Rezoning Transportation Analysis

Petition Number: 2022-210

From: Jake Carpenter, PE
Jacob.carpenter@charlottenc.gov
980-221-5675

Reviewer: Patrick Monroe
Patrick.Monroe@charlottenc.gov
704-301-1411

RZ-03

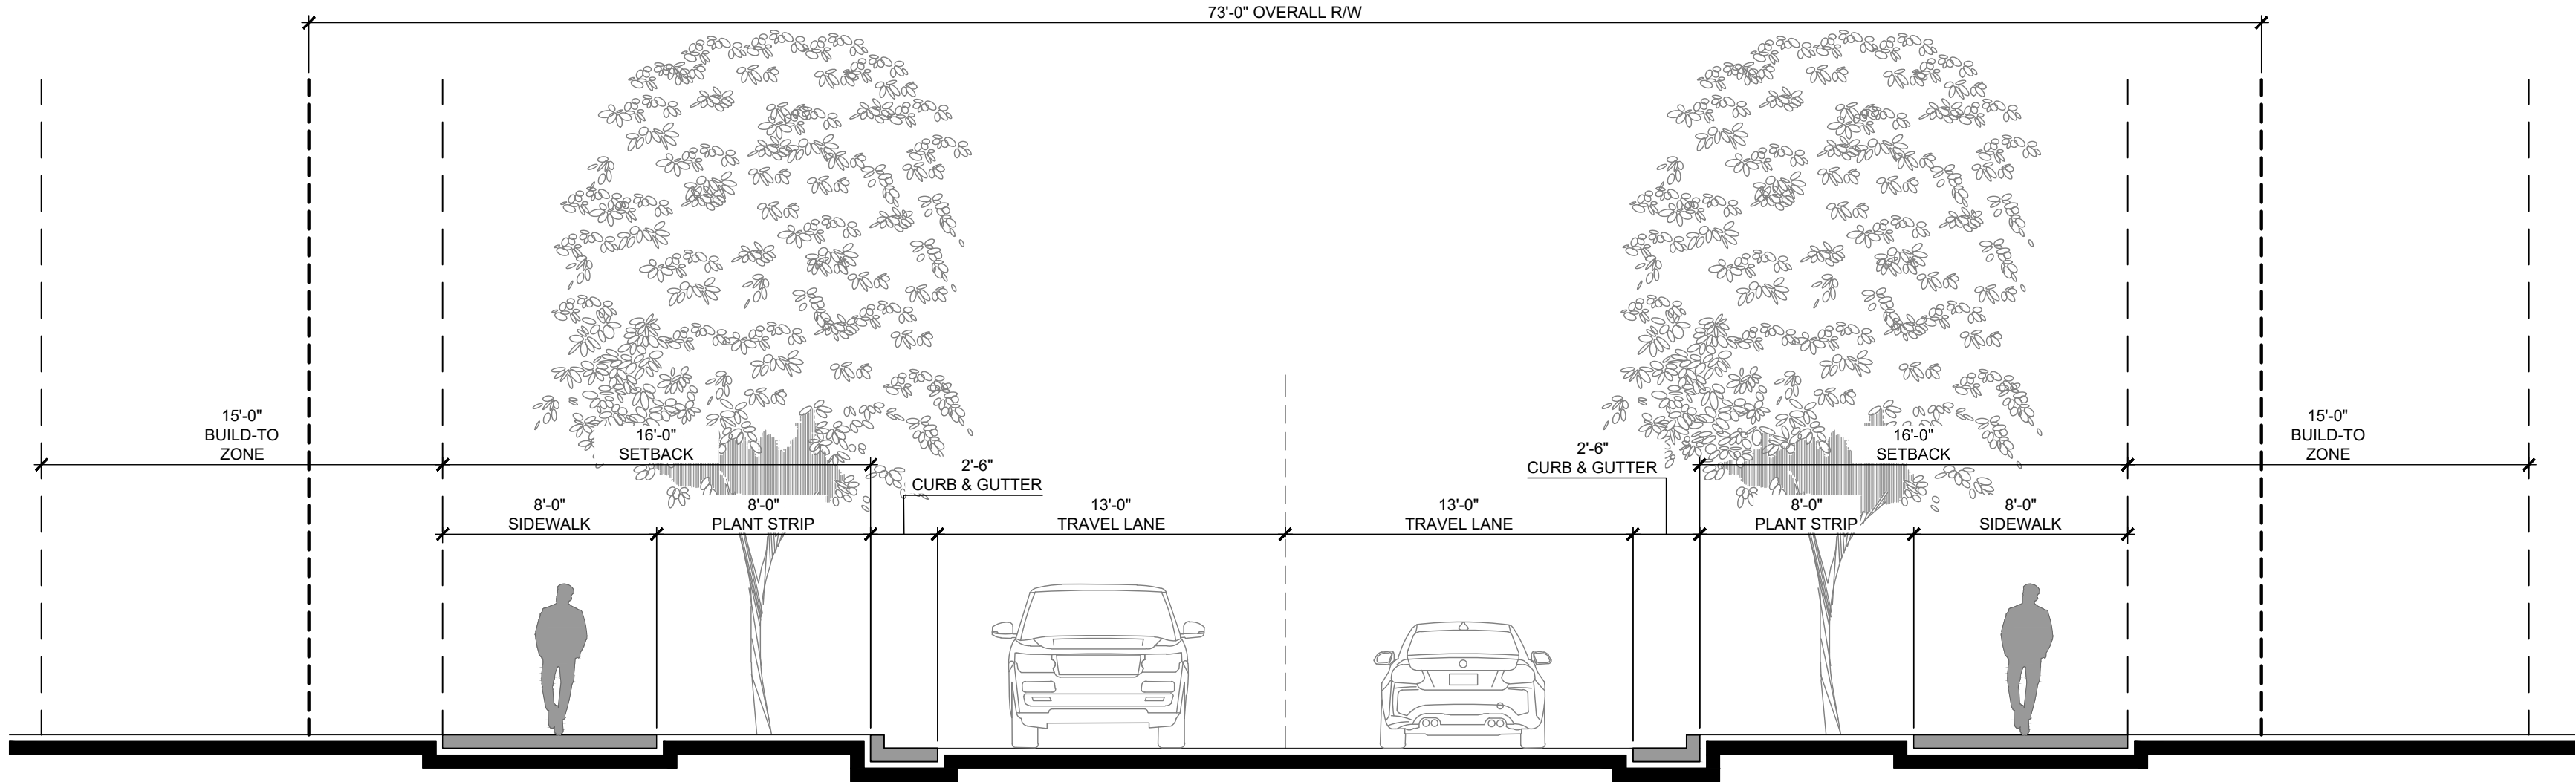
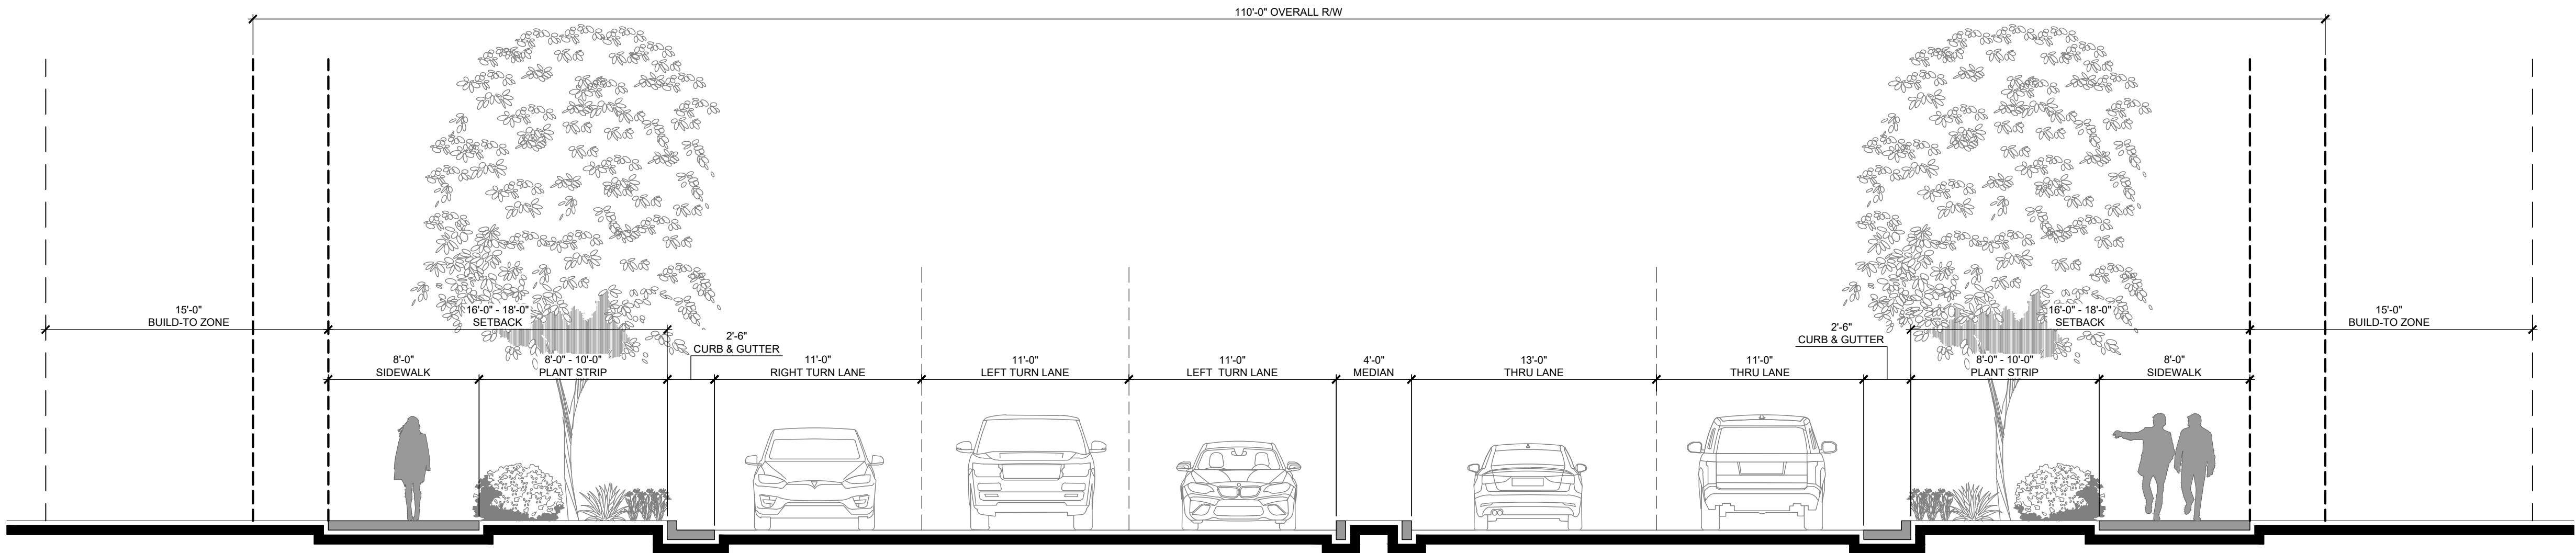
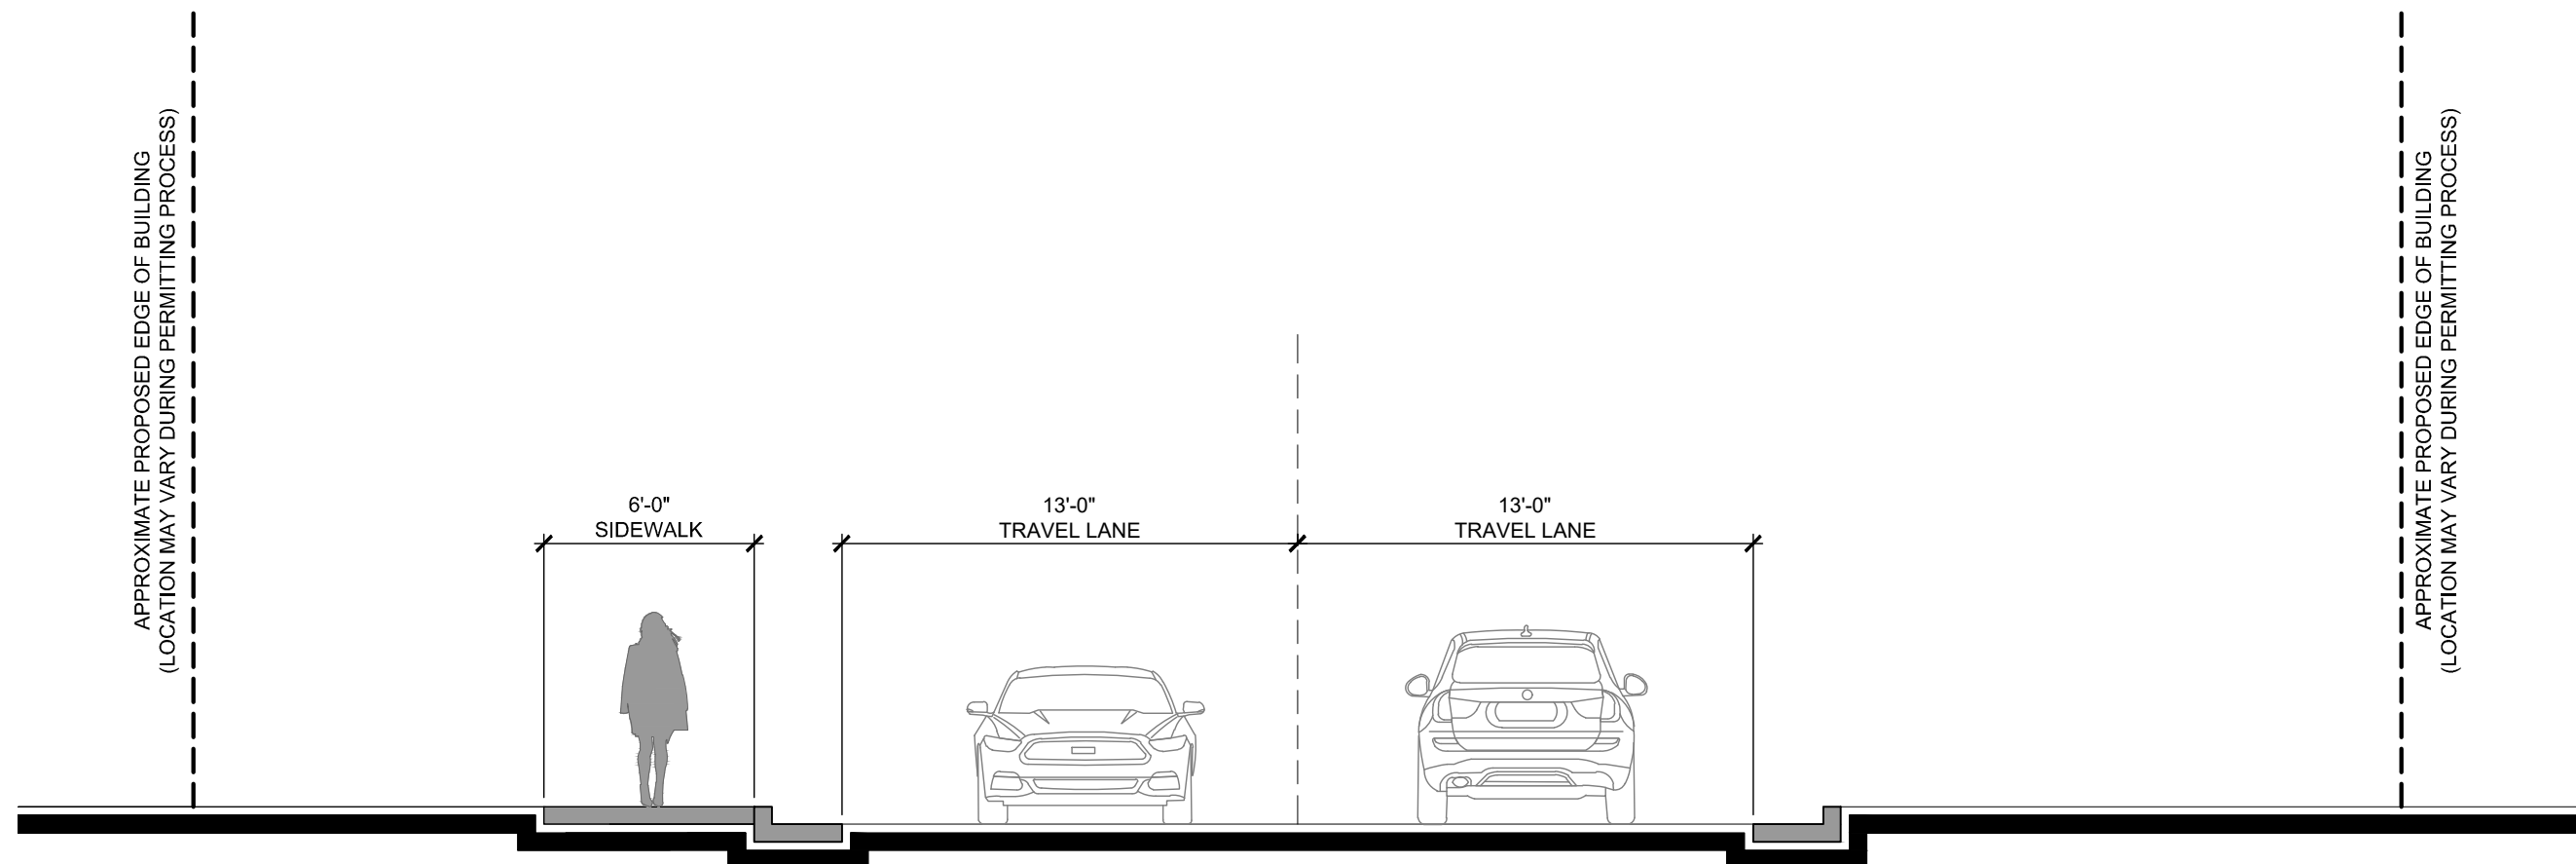
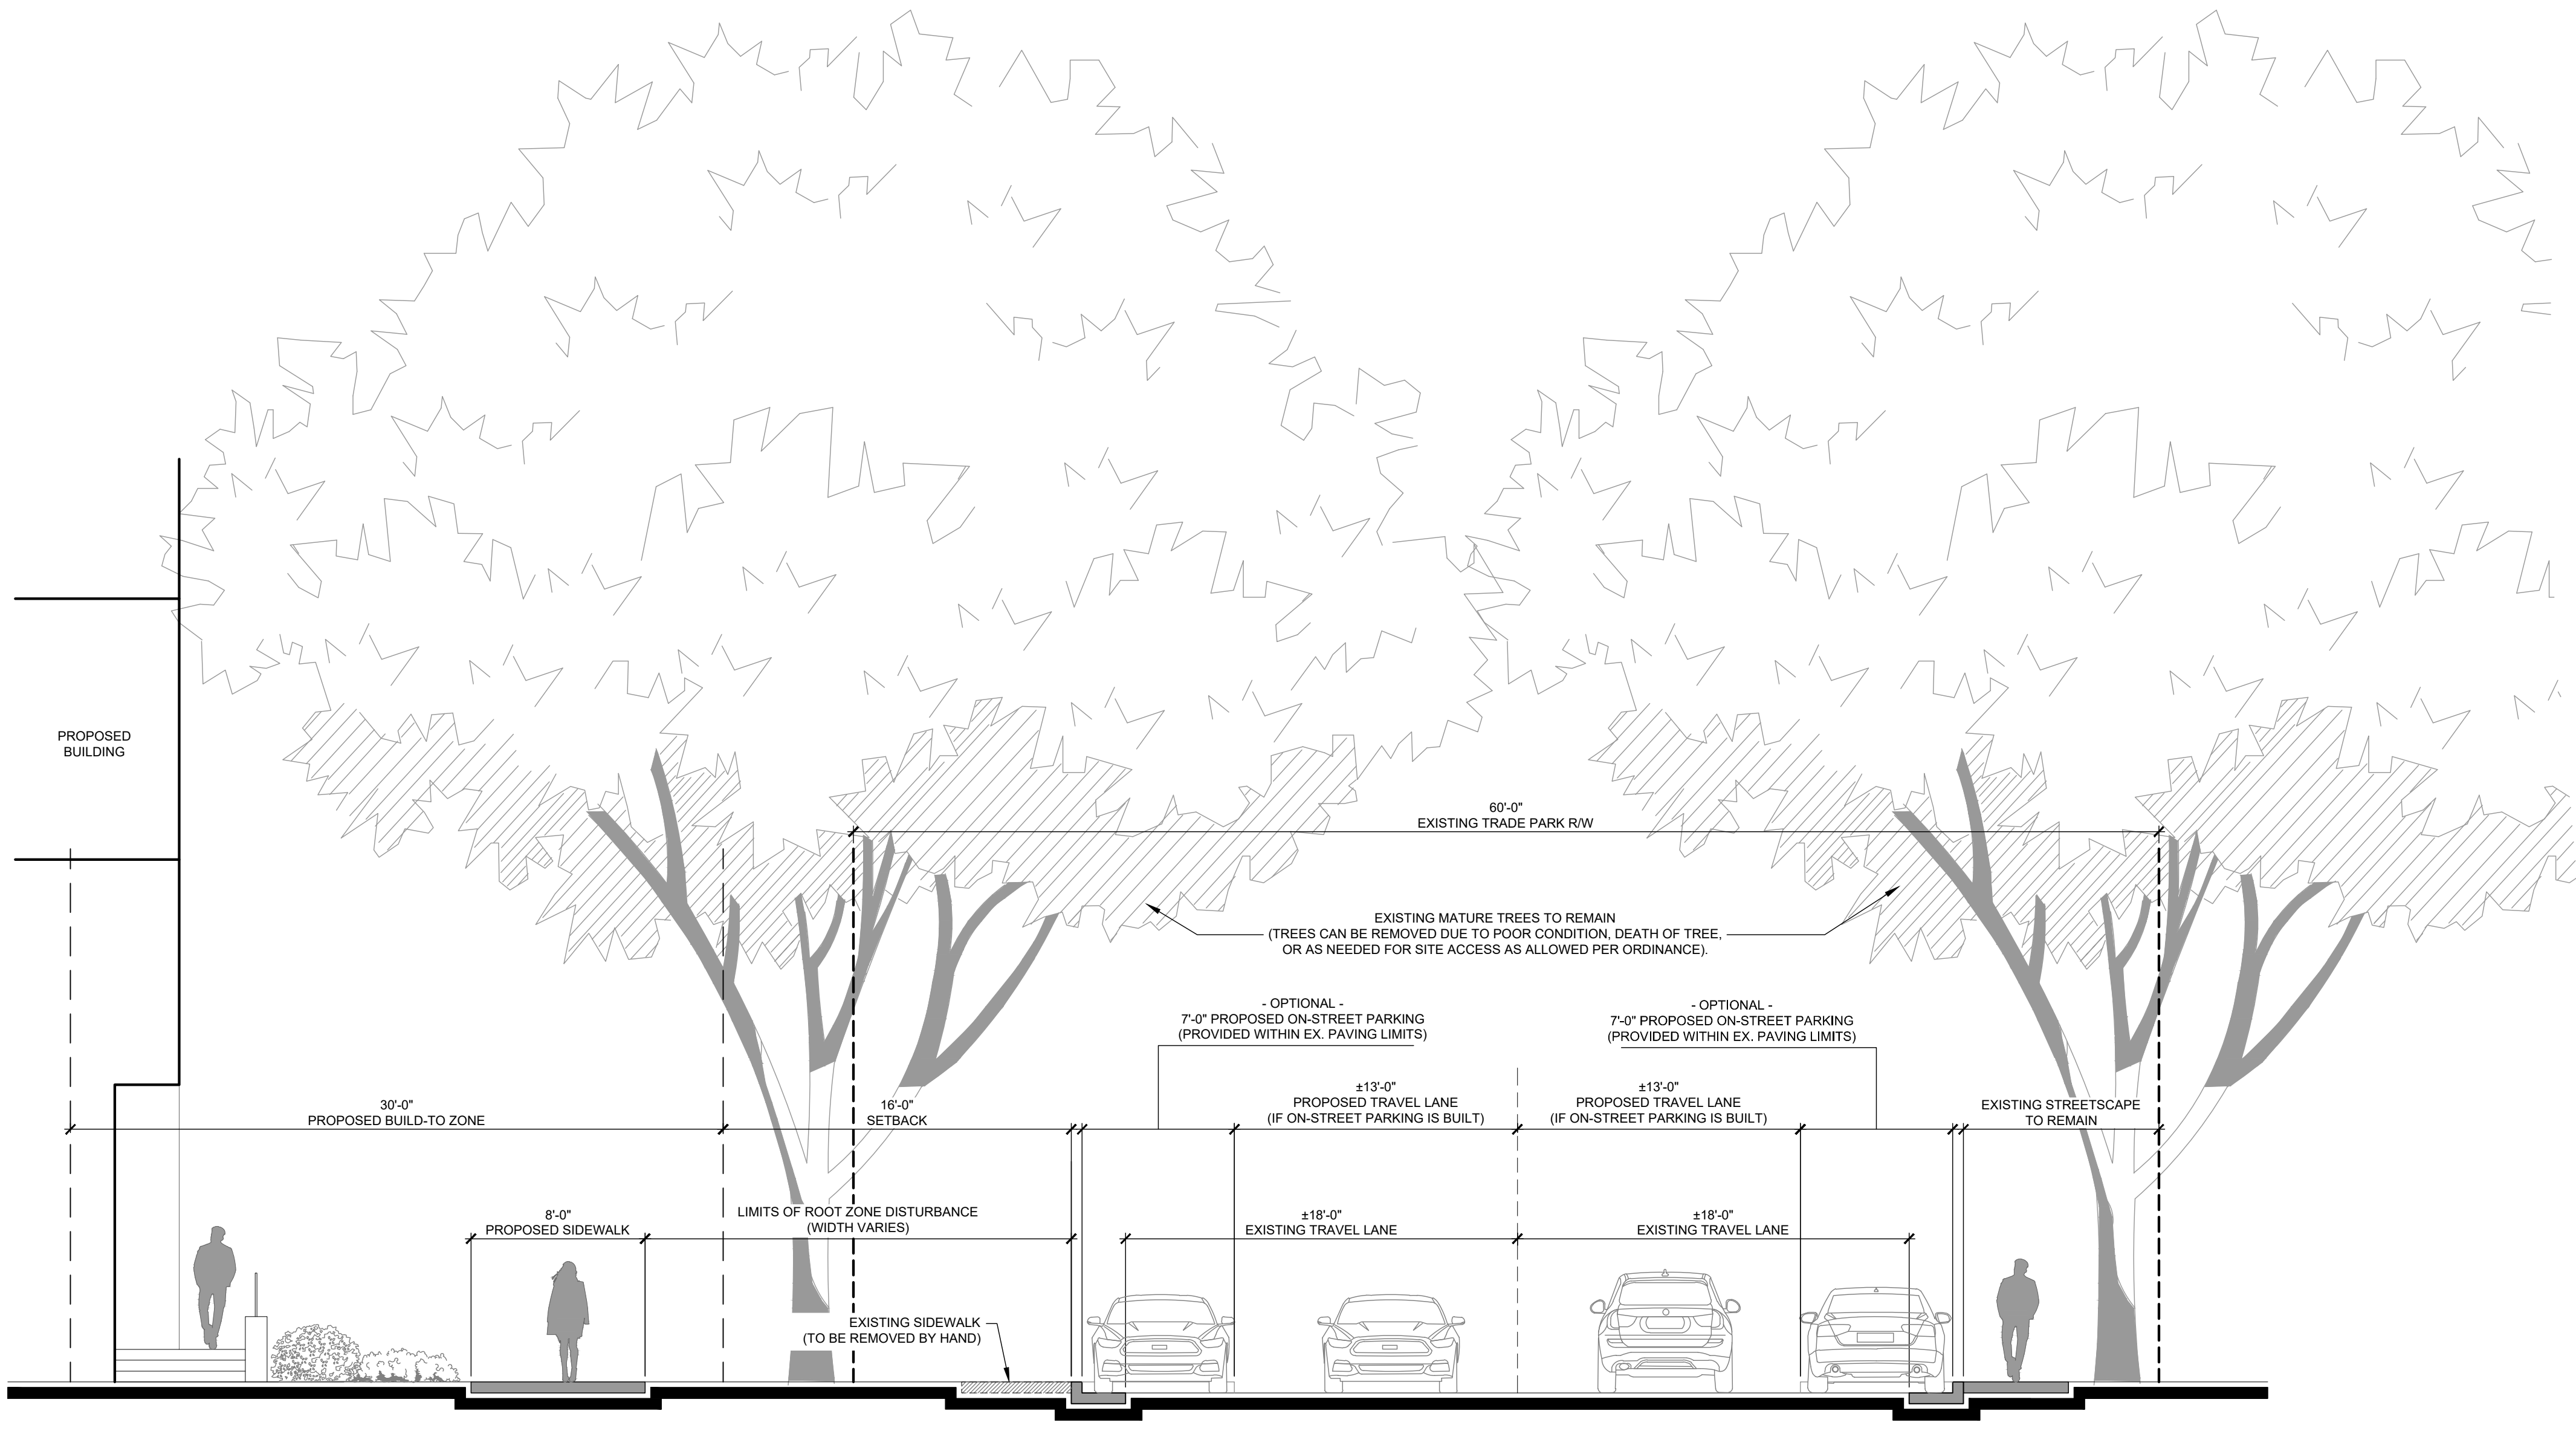
6. **Outstanding Comment 9.20.23:** Revise internal street network to standard public street typical sections per the CLDSM or provide additional information on existing constraints for review and approval of nonstandard typical sections.
